Rezoning Transportation Analysis
Petition Number: Insert Zoning Petition #2020-192
General Location Identifier: Tax ID: 12306409

Revision Log:	Date	Description
	01-21-2021	First Review (LJ)
	03-25-2021	Second Review (LJ)

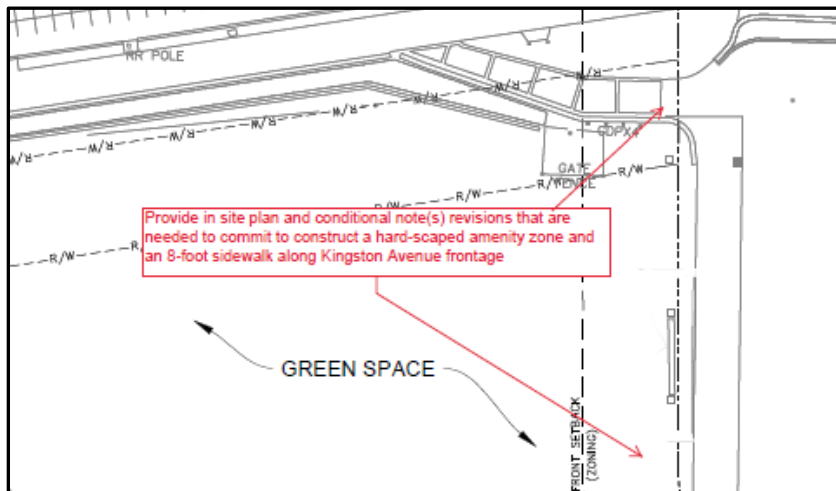
1. **Curbline:** ~~The proposed zoning district has a setback measured from back of the existing curbline.~~
 - a. ~~**Kingston Avenue:** Location of curb and gutter is in its existing location.~~

- b. ~~Label and dimension the curb and gutter from the centerline for each road on the site plan.~~
2. **Traffic Study:**
~~A Traffic Impact Study (TIS) is not necessary for the complete review of this petition due to the site having too many uses to determine if the site generates more than or less than 2,500 daily trips at this time. If during the permitting process the site generates more than 2,500 daily trips, then a traffic study will be required.~~

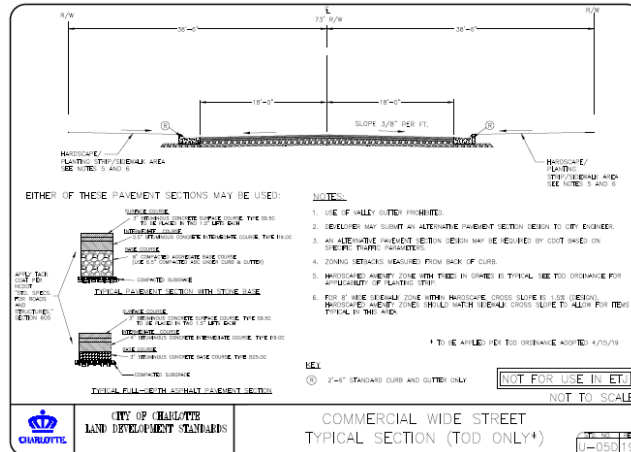
3. **Resolved (03/18/21):** ~~Revise the site plan and conditional note(s) to commit to construct a hardscaped amenity zone and an 8-foot sidewalk along Kingston Avenue frontage adjacent to proposed green space, connecting the Rail Trail access/plaza (per TOD ordinance).~~

~~Reference (CLDSM standard detail U-05D.19 [TOD ONLY]) for street typical.~~
